**WEST SUSSEX COUNTY COUNCIL
STRATEGIC PLANNING CONSULTATION**

**SUBJECT: LU/51/14 - Outline application for approval of access arrangements to serve
68 No residential units.**

**Land South of Littlehampton Academy, Elm Grove Road, Littlehampton, West
Sussex, BN17 6FE**

DESIGN PROPOSALS - LAYOUT

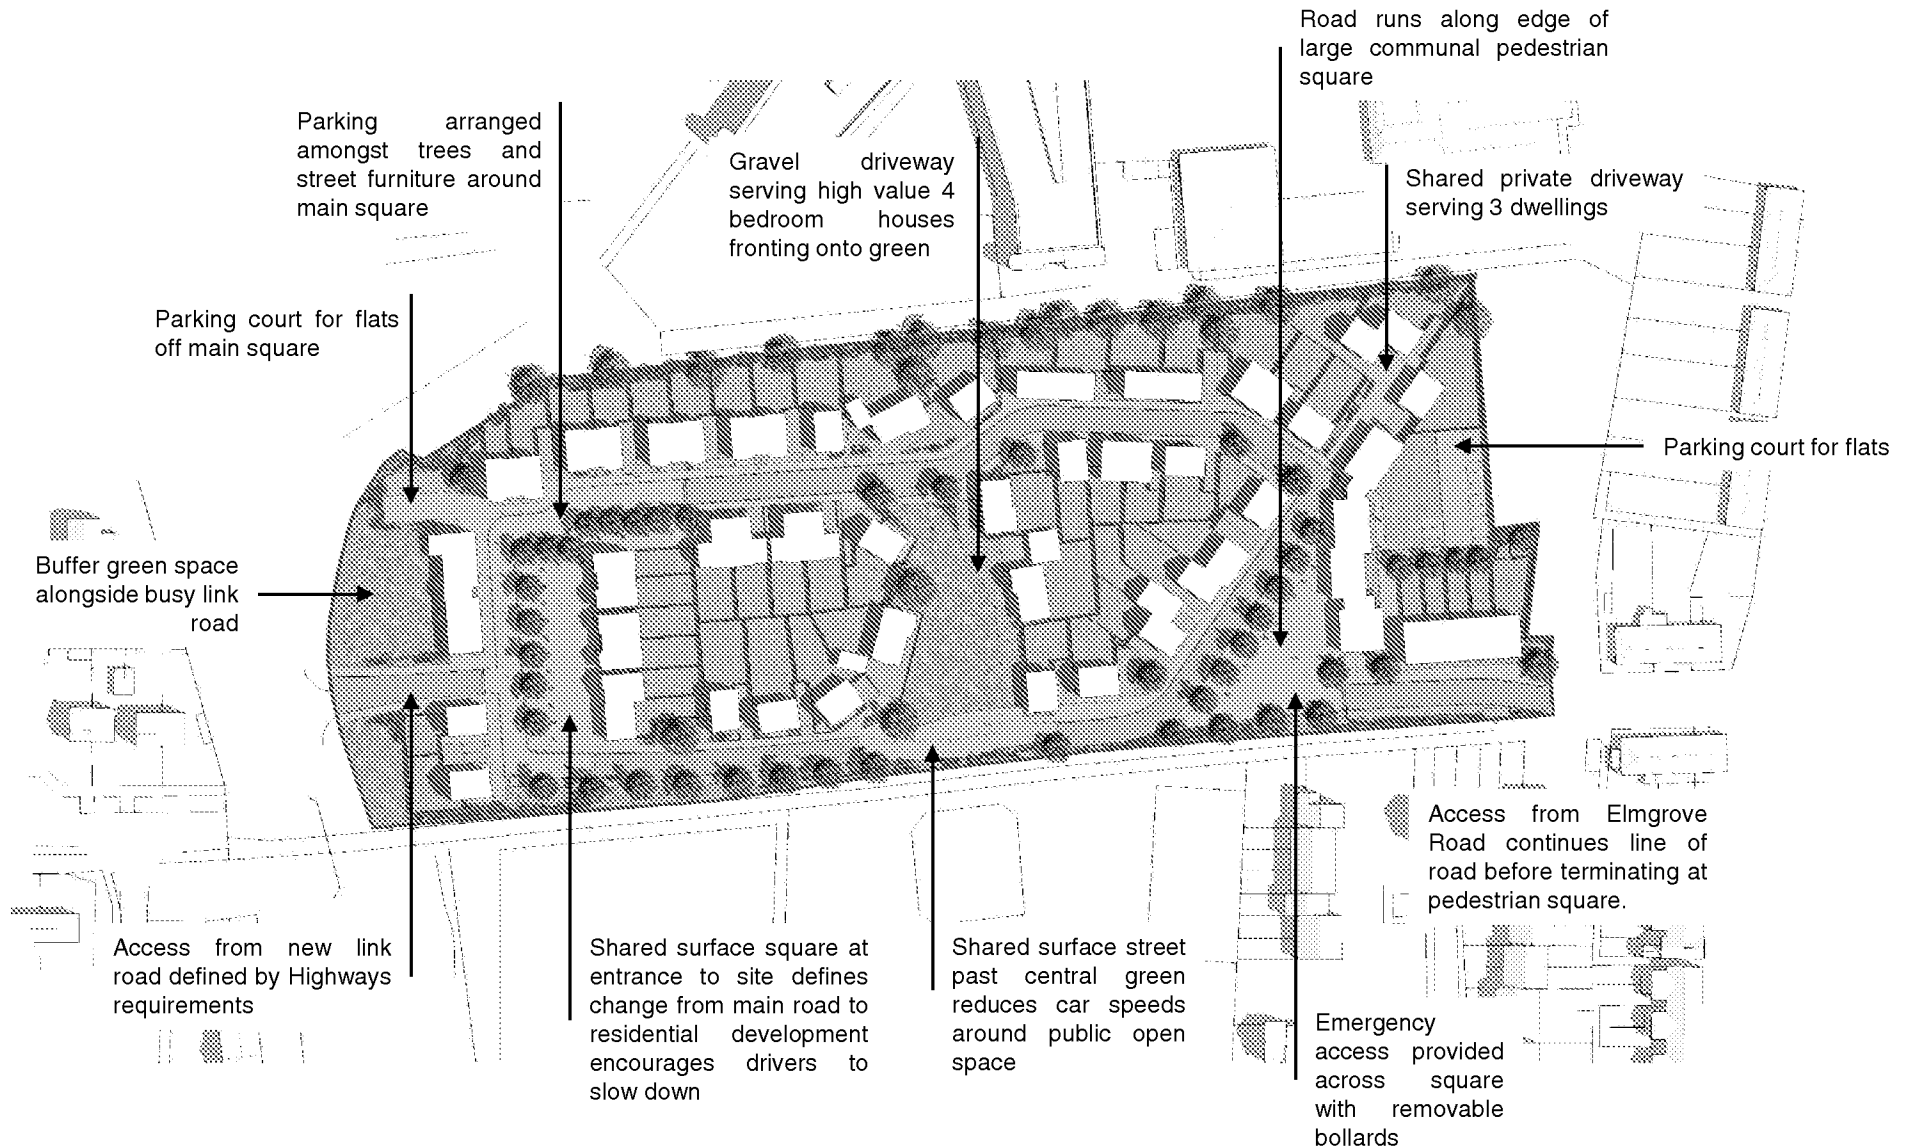
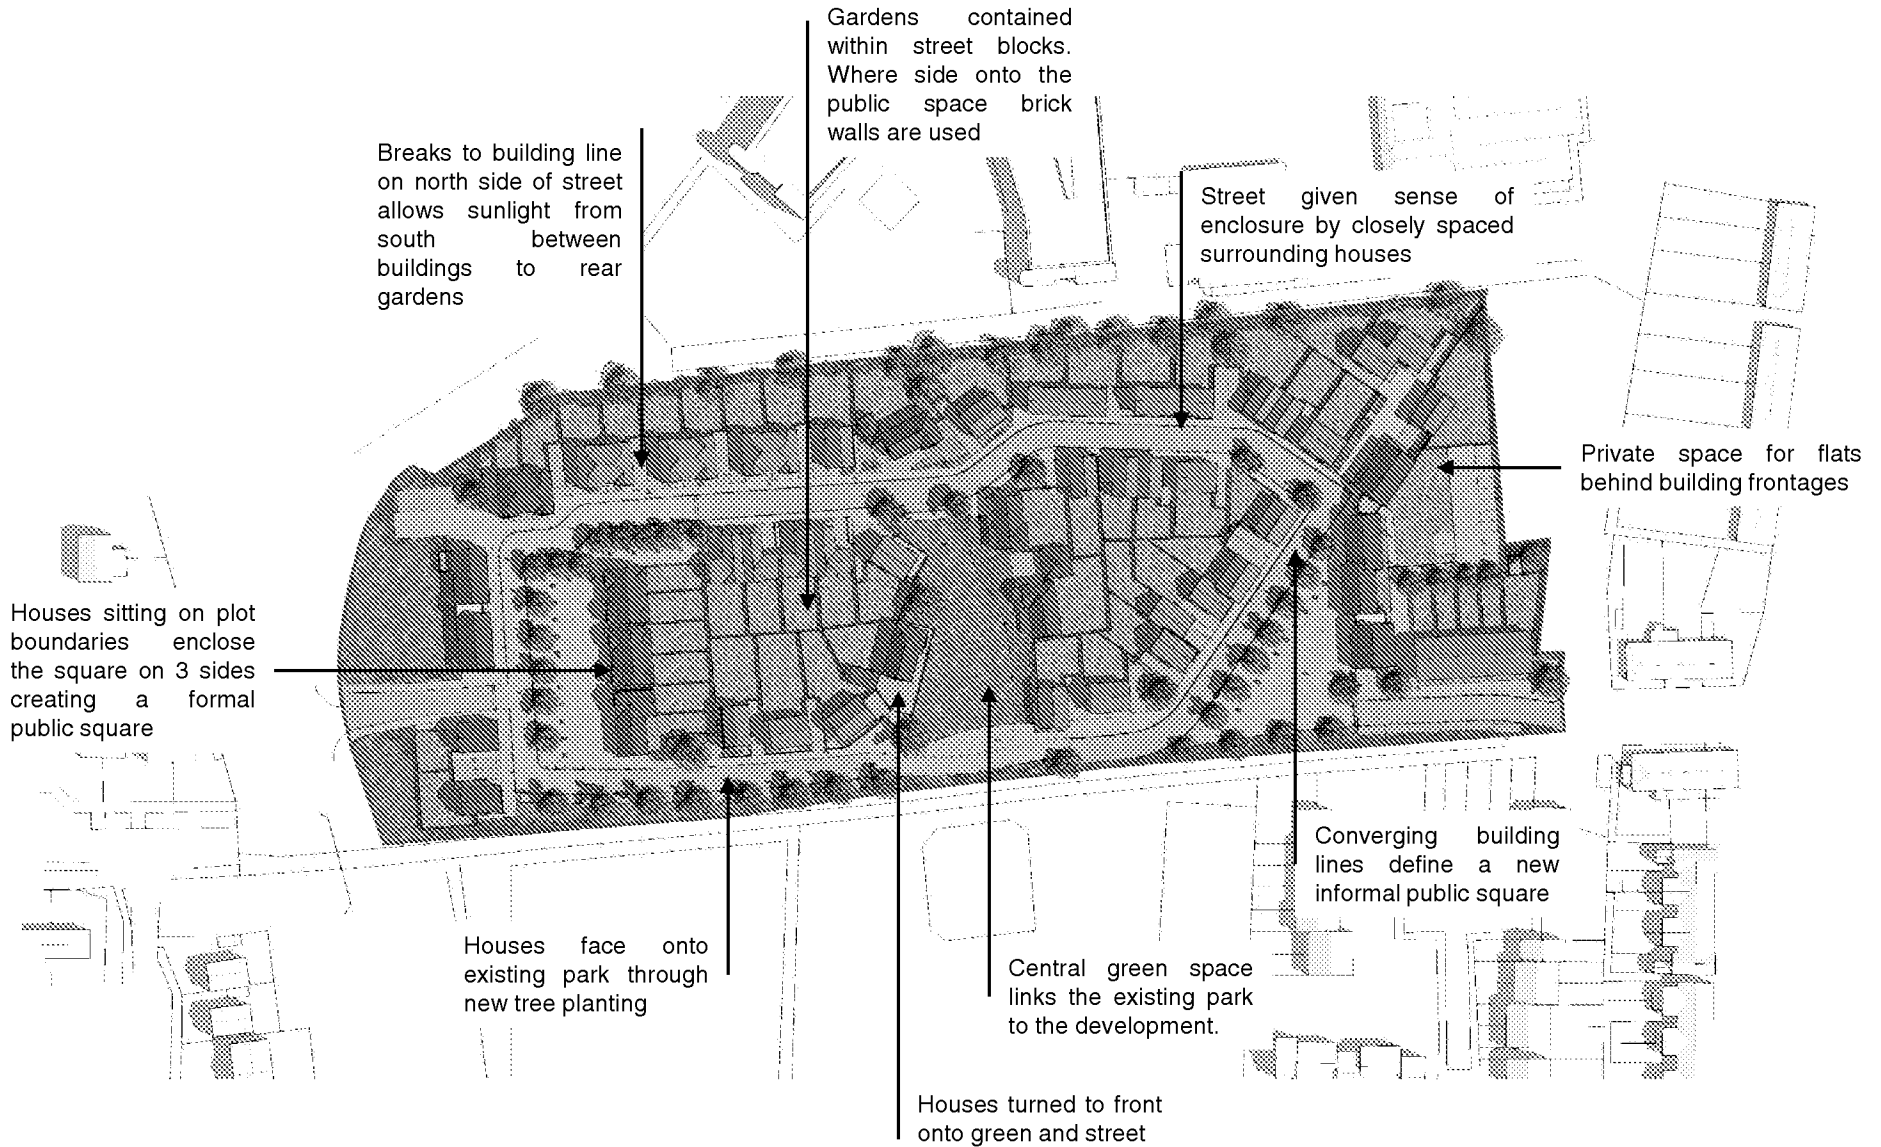
- The layout includes mainly segregated 5.5 metre carriageways and 1.8 metre footways. However there is short section of shared surface. This short section seems unnecessary and would lead to potential difficulties in terms of continuity for partially sighted pedestrians. Whilst there are no issues with shared surfaces being used in a development of this nature, these would need to be better considered.

- It's unclear how the spaces to the front of plots 56-61 are accessed (are they accessed individually from the main access road or via the paved square?). If they are served from the access road, at this stage there would be potential issues raised with vehicles reversing in the vicinity of the main access into the development.

- The parking court for the Elm Grove Road accessed element of the development is detached from those dwellings closest to Elm Grove Road. Residents would choose to park as close to their dwellings front entrances as possible. The parking arrangements should therefore be reconsidered.

- All of the parallel parking bays would require 45 degree splays on both ends.

Client			
West Sussex County Council			
Project			
Land South of Littlehampton Academy			
Drawing Title			
Western Access Arrangement Existing Layout			
Scale	Drawn By	Checked By	Approved By
1:500	PJB	PJC	PMR
Drawing No.	Date	Rev.	
13/1693/003	August 2013	-

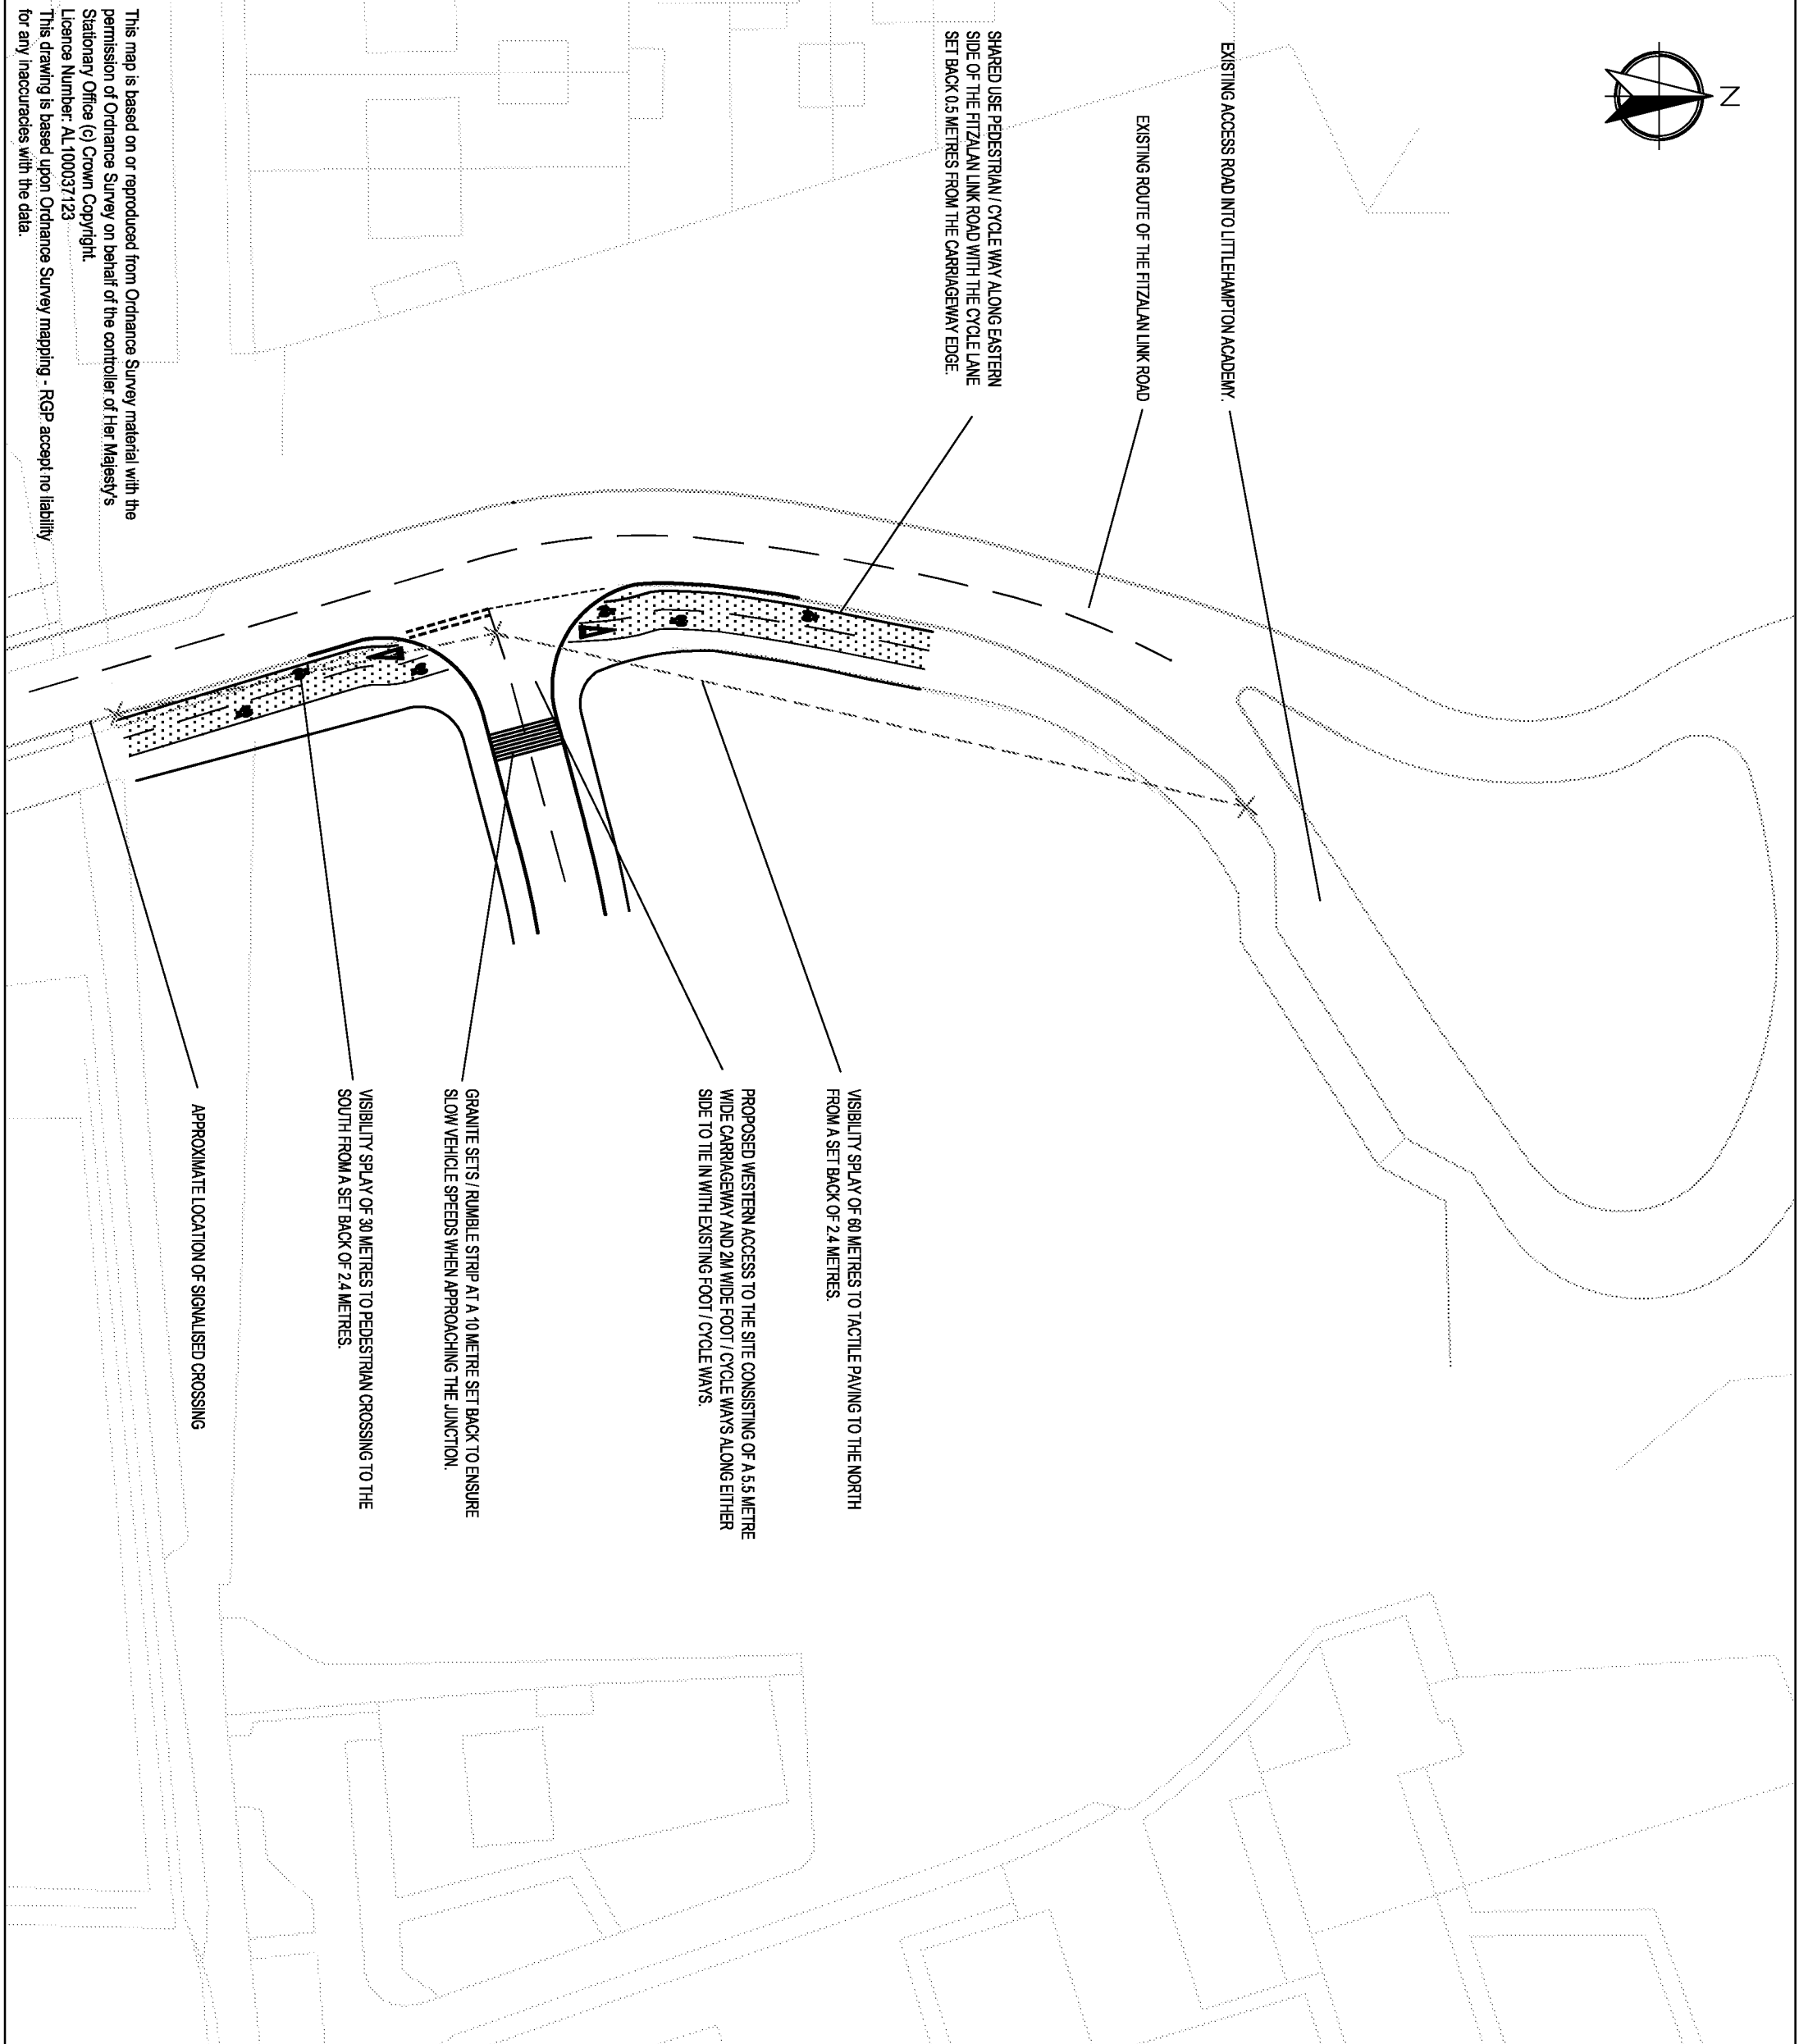
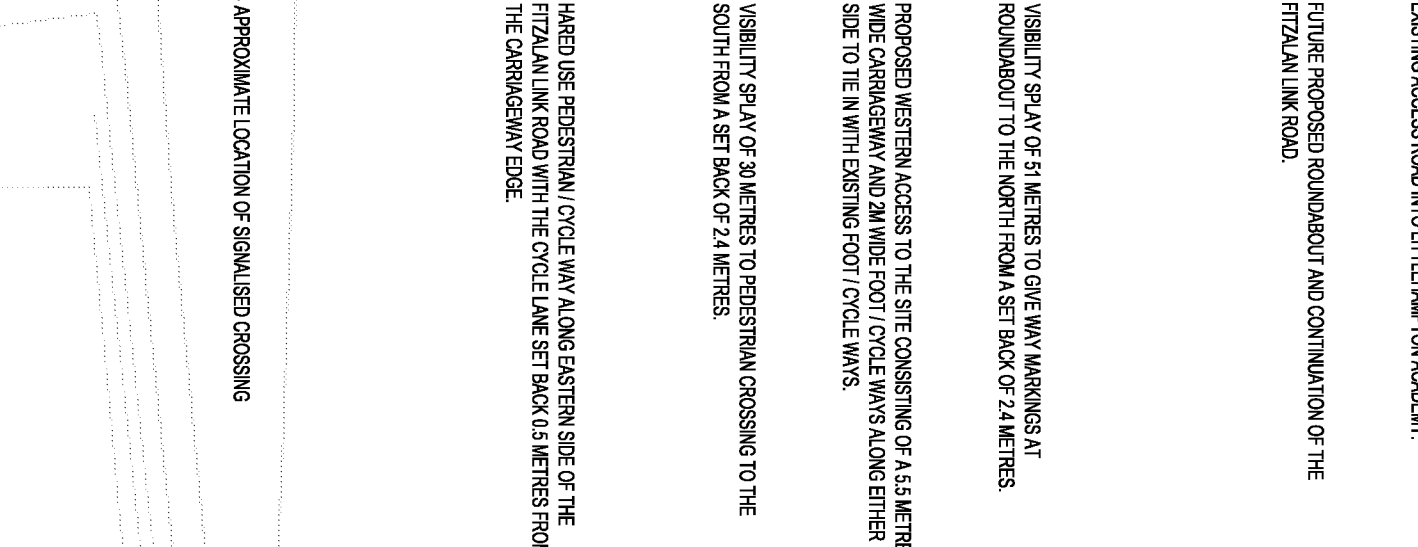
In light of the intention to extend the FLR northwards, two access drawings have been submitted. These show the development access with the FLR as is and extended northwards. The design principles applied to the design of the FLR have been used to determine the arrangements for the new access. Given the 30mph design speed, the principles of Manual for Streets are applicable. Visibility splays of 2.4 metres by 43 metres are shown. The LHA as part of the FLR planning application did raise concerns relating to the potential for inappropriate vehicle speeds along the FLR because of the proposed alignment. The 43 metre sightline from the access to the north is drawn to the Littlehampton Academy arm of the roundabout. A vehicle waiting to emerge from the development would however have a clear sightline beyond the proposed roundabout of southbound traffic. Evidently from the drawings significantly greater visibility splays are achievable.

The drawings demonstrate that the development can be constructed regardless of whether the FLR is extended or not and to ensure the access does not fetter the FLR. From these drawings it is evident that alterations would be required to the development access' northern kerbline to tie in with the extended FLR. These changes are only minor and would be entirely within what will be public highway. As there is no certainty as to when the FLR or the development would be built, it is recommended that the access arrangement is secured by condition, requiring plans and details to be submitted. The respective access arrangement would then need to be submitted to discharge the condition depending upon the situation with the FLR at the time the development comes forward.

In both situations, the existing TOUCAN crossing to the south of the development access will remain. The guidance within LTN 2/95 (Design of Signalised Pedestrian Crossings) requires a minimum 20metre distance from the position of the emerging vehicle to the crossing. The drawings submitted indicate a distance of 30metres is achievable. The access would not affect the operation of the crossing point.
